Application Ref:	3/2025/0315			 Ribble Valley Borough Council <small>www.ribbonvalley.gov.uk</small>
Date Inspected:	N/A	Site Notice	11/06/2025	
Officer:	MC			
DELEGATED ITEM FILE REPORT:				APPROVAL

Development Description:	Listed Building Consent for reconfiguration of the art department entrance and reconfiguration of the CCF and IT classrooms to create Textiles and Design Technology teaching spaces.
Site Address/Location:	Stonyhurst College Avenue Road Hurst Green Clitheroe BB7 9PZ

**Proposed Floor Plans - Art**

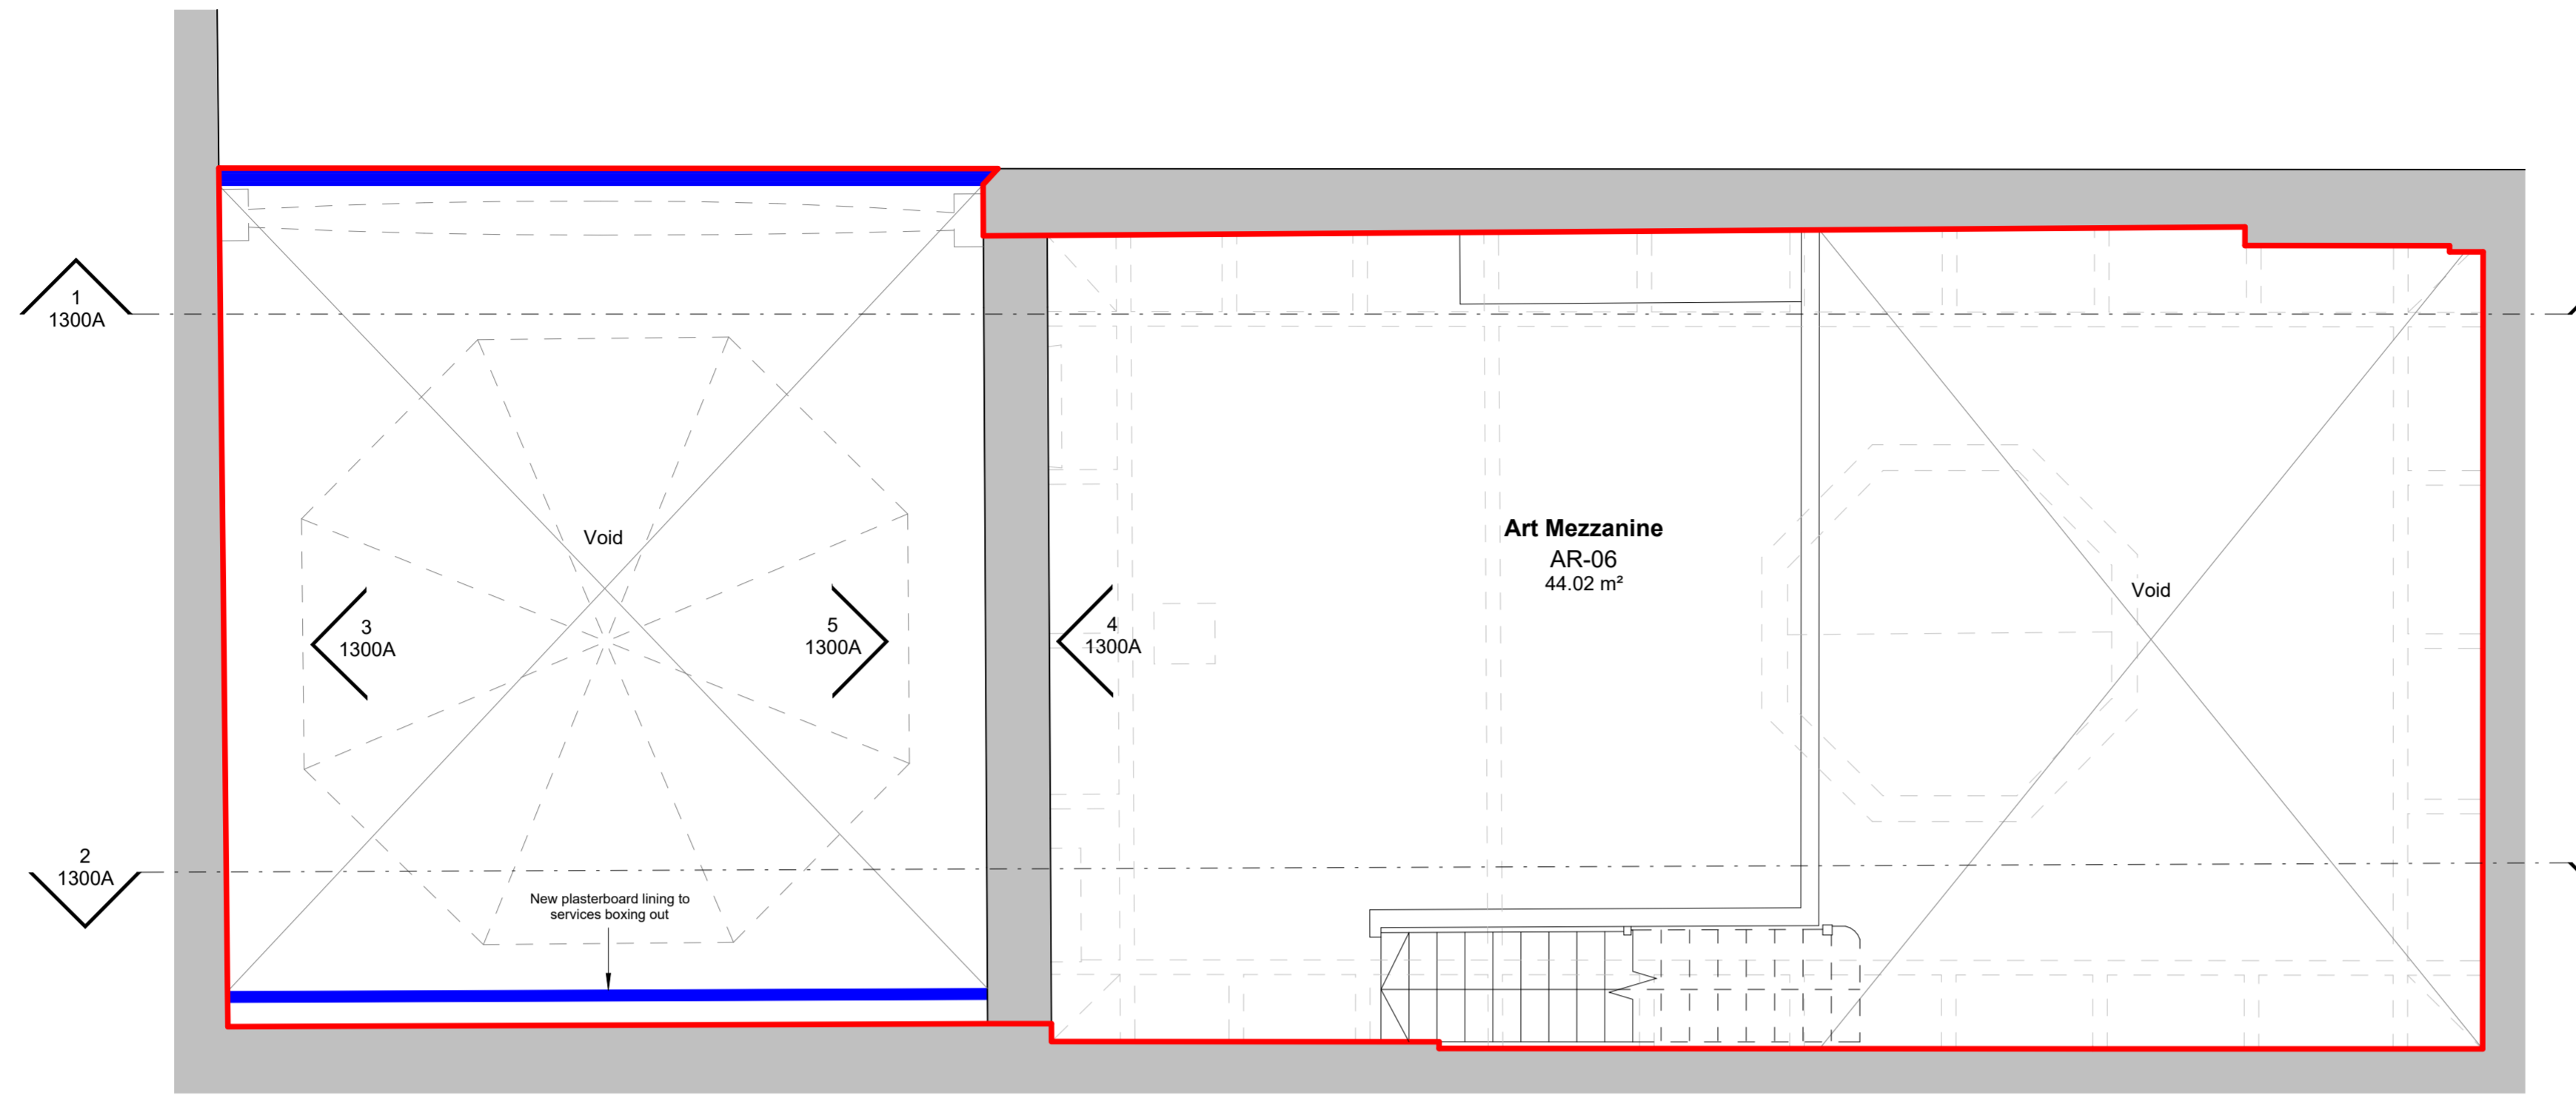
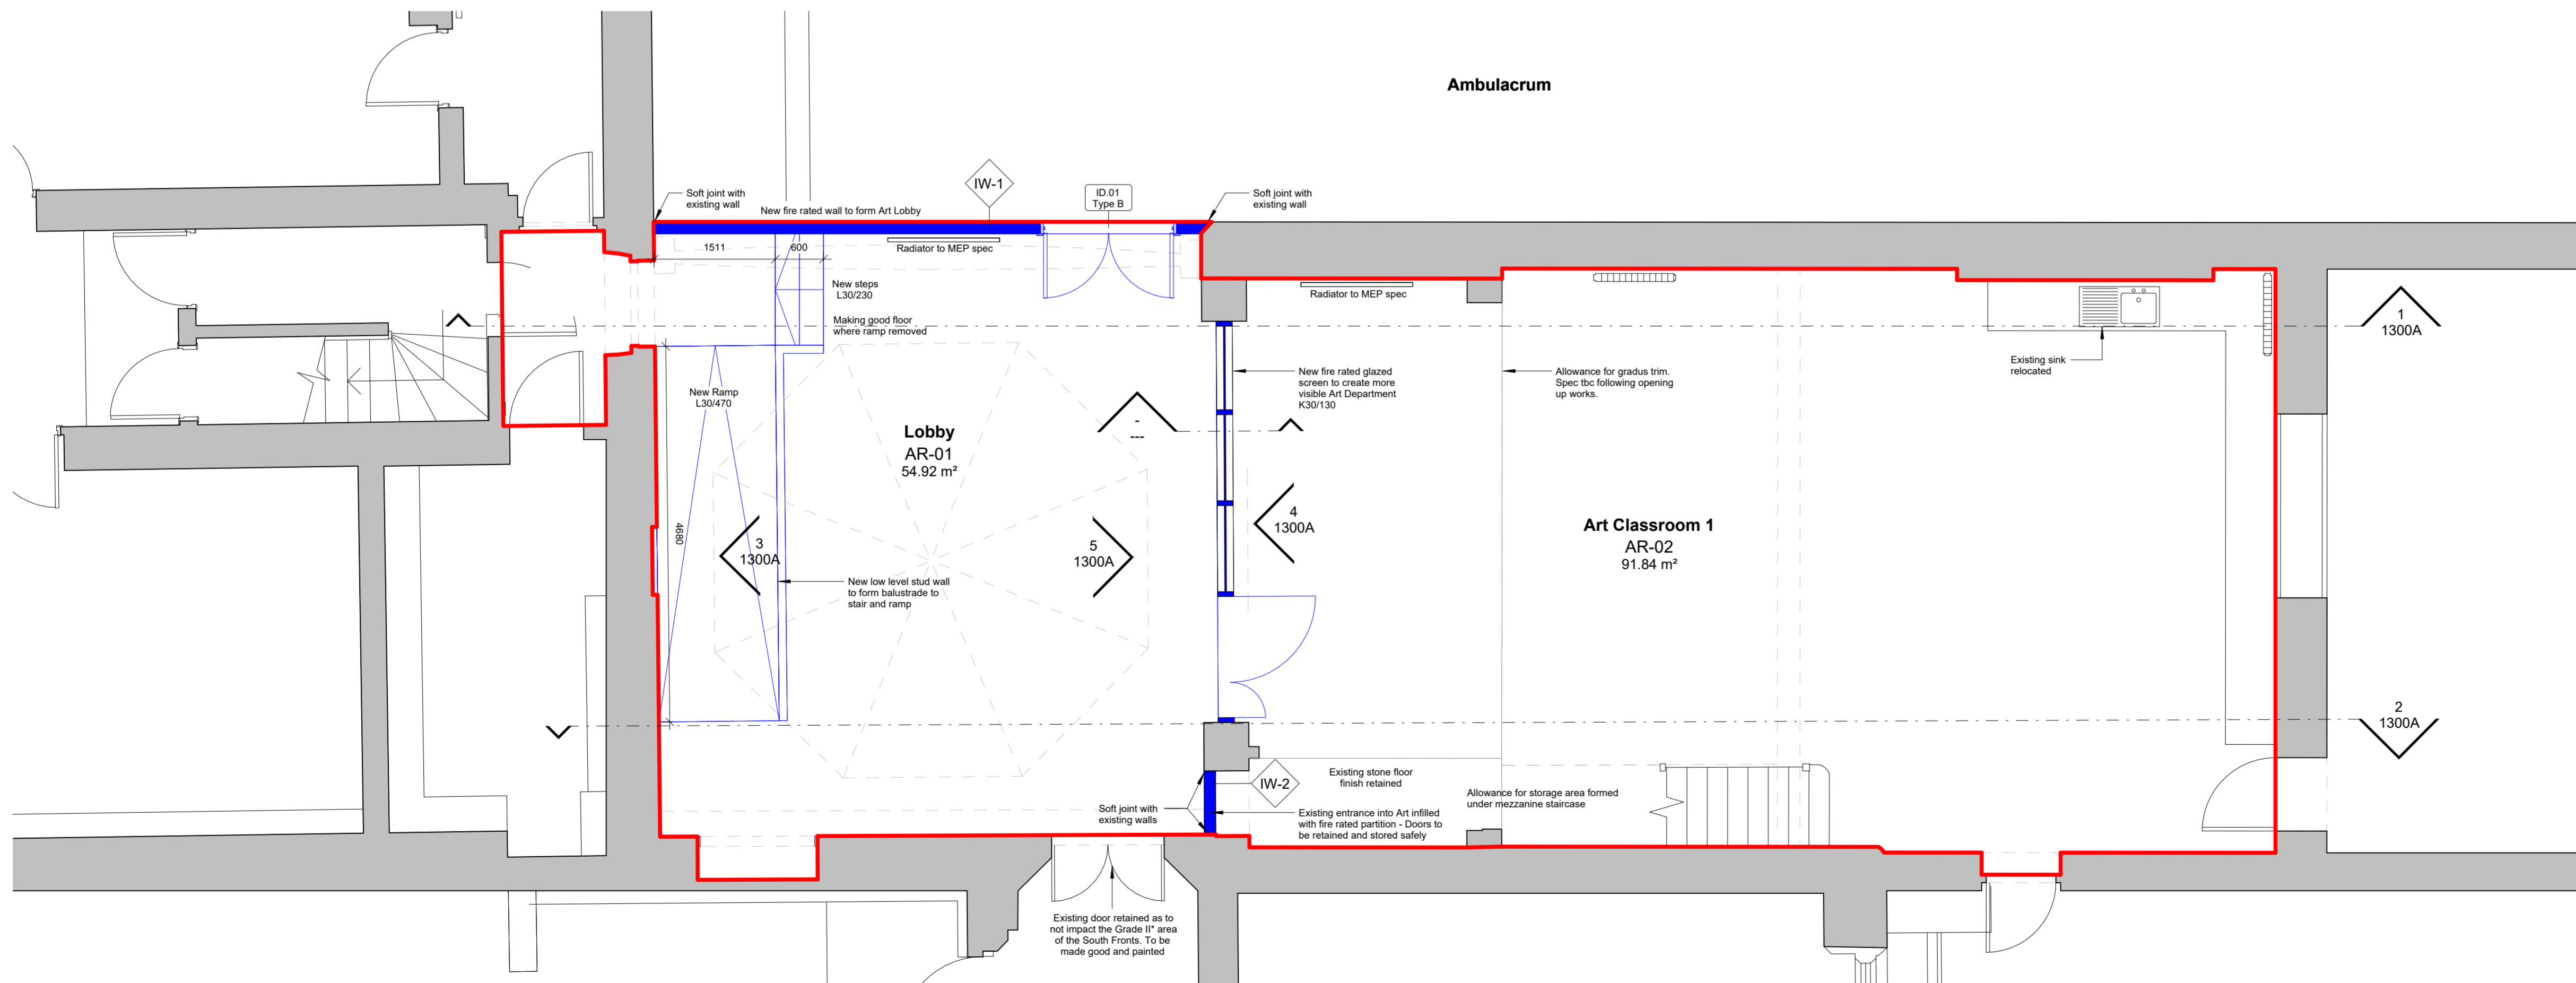
The proposed development includes works to the existing art department. The works include the demolition of some limited masonry fabric for creation of a wider, more centrally placed entrance into the art department, which is historically significant to the college. In addition, the proposal includes the removal of the modern partition of the storage room and the creation of a new entrance to the lobby and new glazed screening between the Lobby and Art Classroom 1. A C19 door would be removed in placed in storage and an existing unsympathetic C20 storage room, C20 cupboards attached to the walls and a C20 ramp and low level modern walls would be removed in the lobby. removal of a C20 ramp

The proposal originally included new glazed openings to the mezzanine floor, however following consultation with the Heritage and Conservation Officer, these have now been omitted from the scheme.

They note that the proposed works would result in the creation of a wider, more centrally placed entrance into the art department, which is historically significant to the college. Currently there is no division between the art dept and ambulatory, and the appreciation of the ambulatory is somewhat hindered by the presence of a large access ramp and views into the art dept and the modern, more functional cupboards and accretions.

The Heritage and Conservation Officer considers there to be heritage benefits to the scheme which include the removal of the unsympathetic C20 storage room, C20 cupboards attached to the walls, removal of a C20 ramp which takes up considerable space below the lantern and re-placing in the west wall in a more discrete location, which will allow the historic ambulatory space and former labs to be appreciated more fully. They also consider that the proposed works to the CDT block will have no bearing on the significance of the listed building.
